**Consultation Response from KC,
Highways Development Management**

2026/91571 Land off, Linfit Lane, Kirkburton, Huddersfield, HD8 0TX

Prior notification for proposed alteration of private way for agricultural use

Date Responded: 9 July 2026

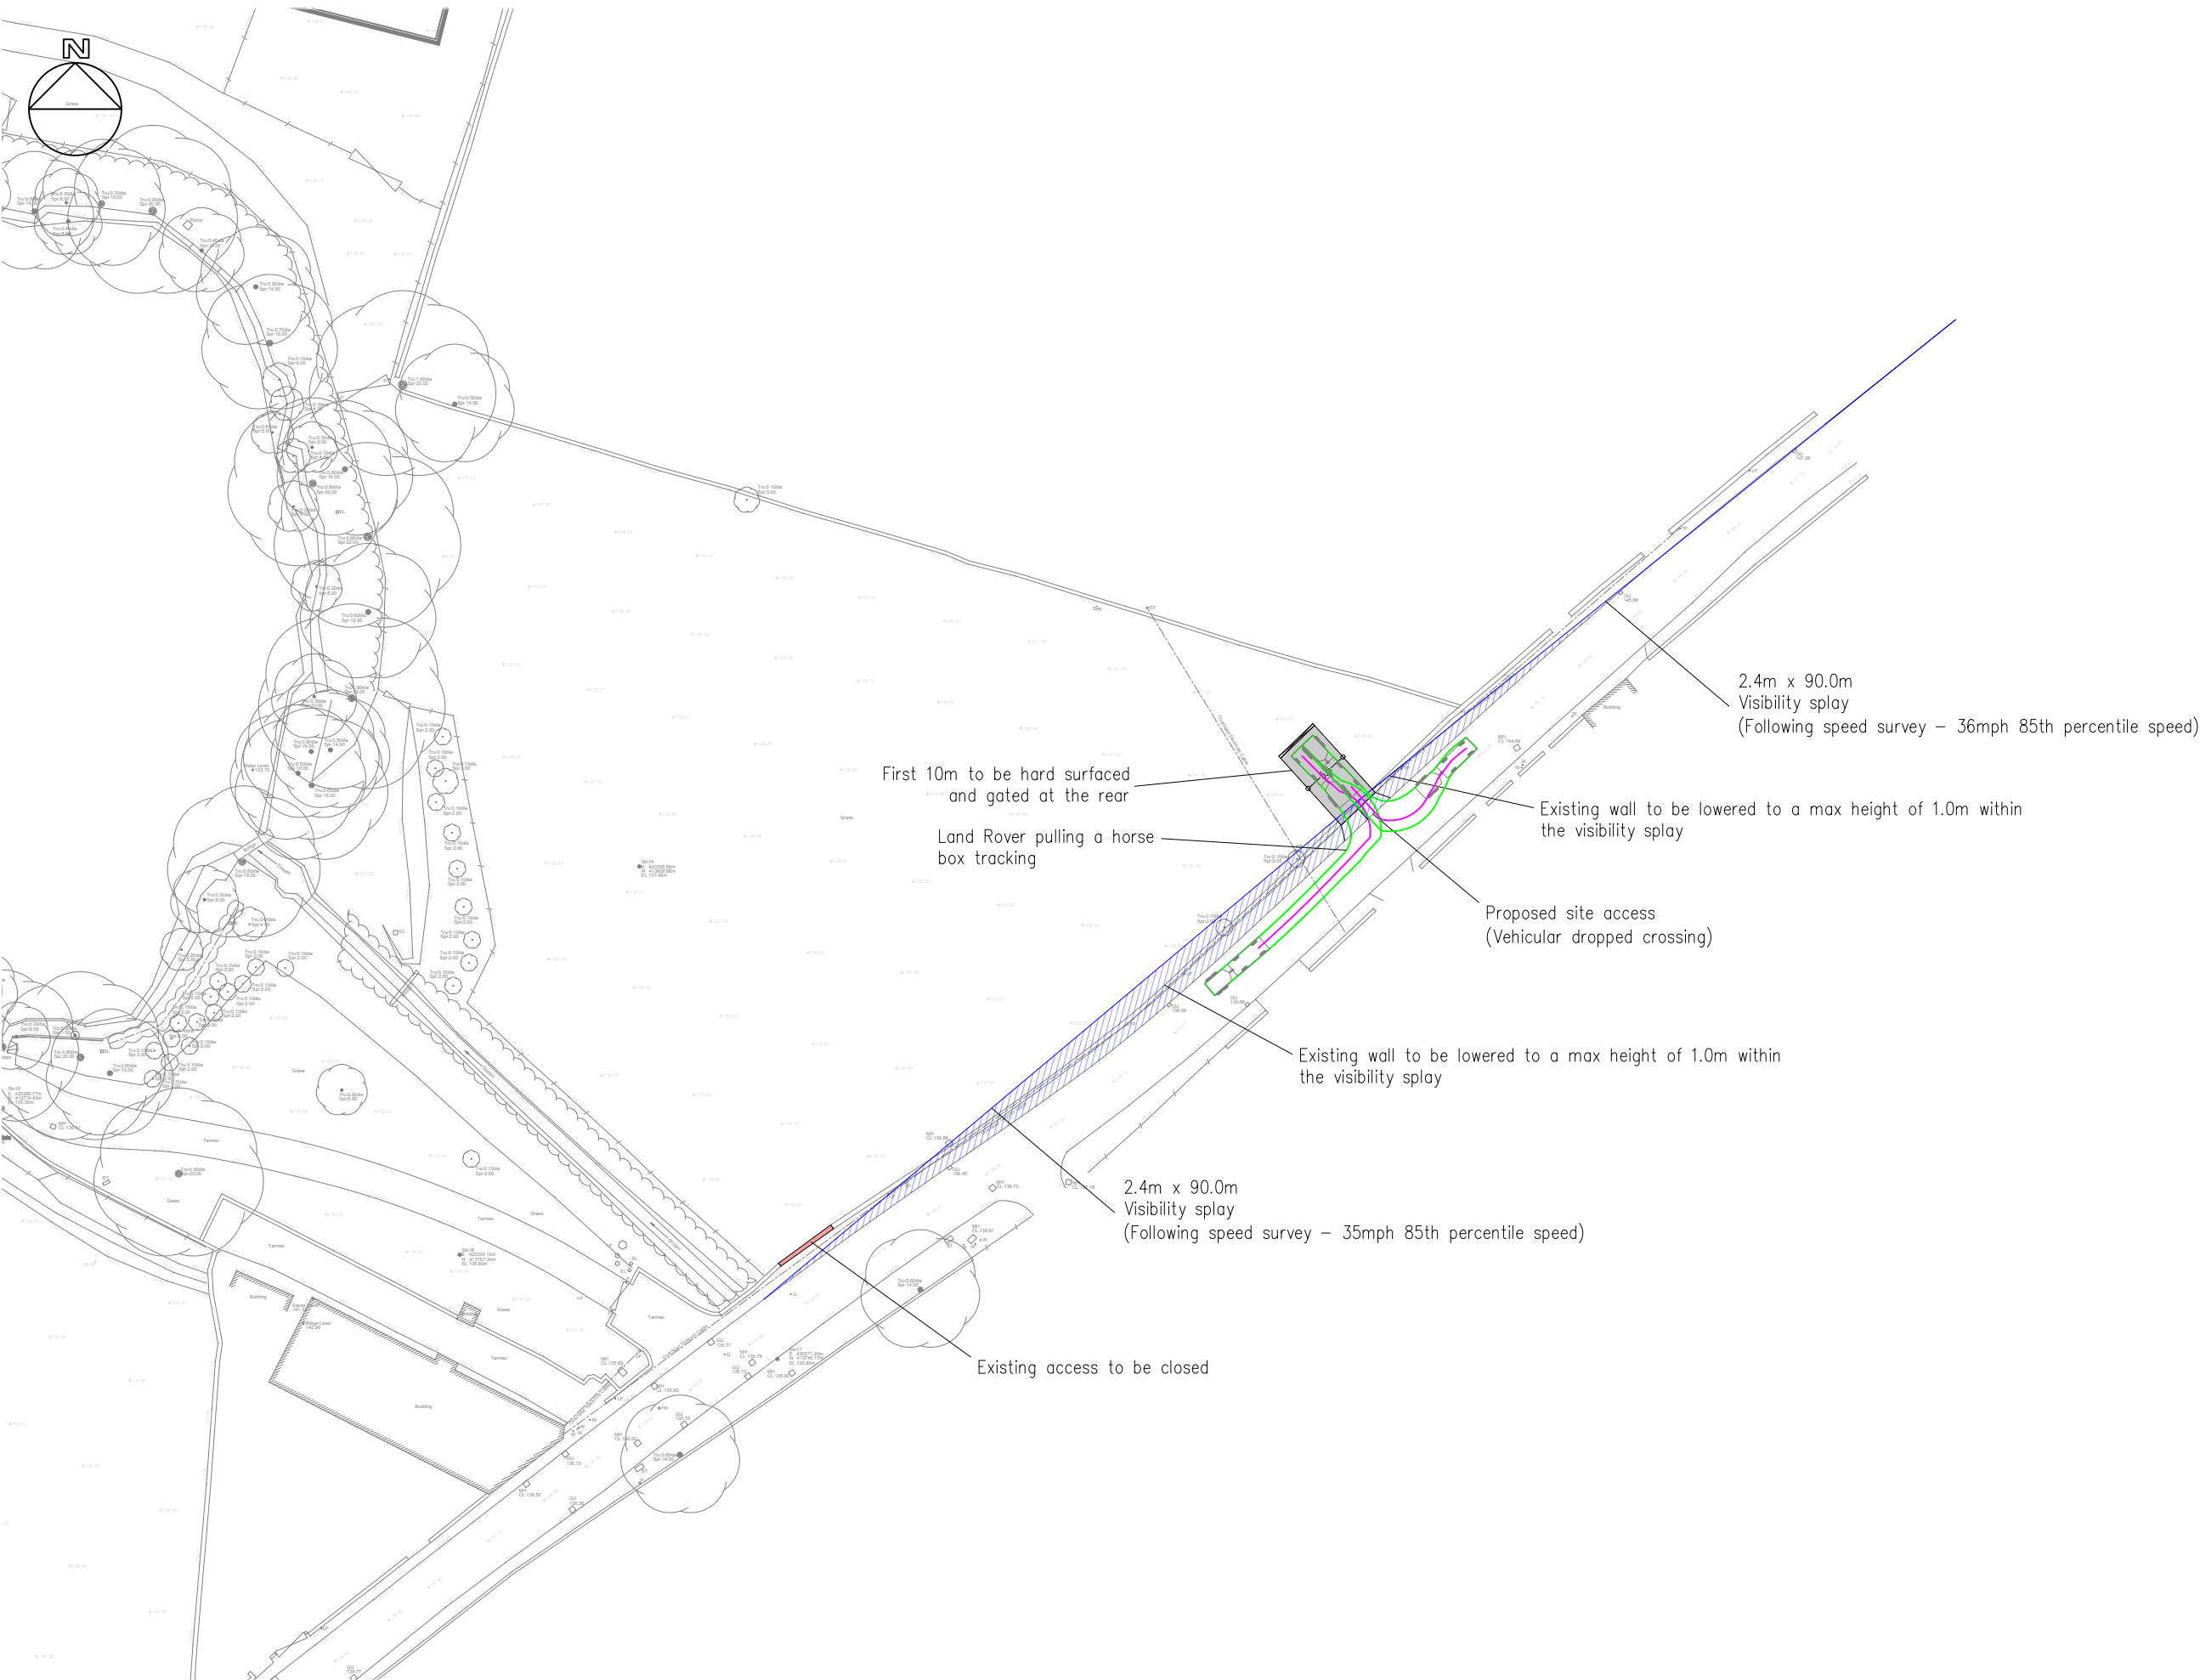
The proposed new recessed and gated access for agricultural use is to be positioned some 80m to the north of the existing. It is to have entry spays, a 5.5m width for the first 10.0m into the site and hard surfaced on altering the boundary. 2.4m x 90m visibility splays are to be provided in each direction based on the Design Manual for Roads and Bridges guidance for recorded 85th percentile vehicle speeds rather than the 60mph speed limit. Recorded 85th percentile speeds in March 2026 were approximately 35mph northbound and 36mph southbound. Sections of the existing boundary wall along the frontage are to be reduced to a maximum height of 1.0 metre above adjacent carriageway channel level to ensure suitable intervisibility between drivers emerging from the access and approaching vehicles on Linfit Lane. The new access would replace an existing access to its south which would be closed and the boundary and land reinstated.

The proposed access would be an improvement over the existing by being hard surfaced before entering and exiting onto the carriageway thereby reducing the risk of mud and debris being tracked onto the highway from waterlogging. The hard surfacing must be in an approved surface material, such as tarmacadam.

It would increase the lines of sight. Visibility to the south from the existing access is currently restricted to approximately 22 metres, resulting in a shortfall of approximately 68 metres when compared to the required standard with higher recorded speeds on passing of 43mph northbound and 42mph southbound.

Additionally, it would allow vehicles to pull off the road more quickly on arrival and not overhang on departure due to the recess. Vehicles would be able to conveniently and safely enter and exit the field in a forward gear demonstrated at Appendix B of the submitted Technical Note which shows vehicle tracking for the anticipated vehicle types associated with the use of the field of a Land Rover towing a horse box that is likely be transporting horses, other livestock, or supplies, etc. The proposed gates will need to open inwards.

The new access will require a dropped crossing of the footway and unlikely to require removal of any utility poles. These works will require a separate permission from Highways.
<https://www.kirklees.gov.uk/beta/transport-roads-and-parking/dropped-kerbs.aspx>

- a) **Approved Access and Visibility Splays:** Prior to the first use of the development hereby authorised, the means of vehicular access to and from the site shall be laid out, constructed and made operational in the position shown on the approved plan 2547 0001A, including a dropped crossing of the footway, entries splayed outwards at an angle of 45 degrees, visibility splays of 2.4 x 90m in each direction, gates setback 10.0m and hung to open inwards only. The area of access road within 10.0m of the carriageway edge shall be surfaced in a bituminous macadam or other approved material. The visibility splays shall be retained clear of all obstruction to visibility greater than 1.0m in height above the adjoining carriageway for the lifetime of the development.

- b) **Closure of Redundant Access:** The existing access to the highway as marked on the approved plan 2547 0001A shall be permanently closed and the footway and boundary reinstated in accordance with a detailed scheme to be agreed by the Local Planning Authority concurrently with the bringing into use the new access.
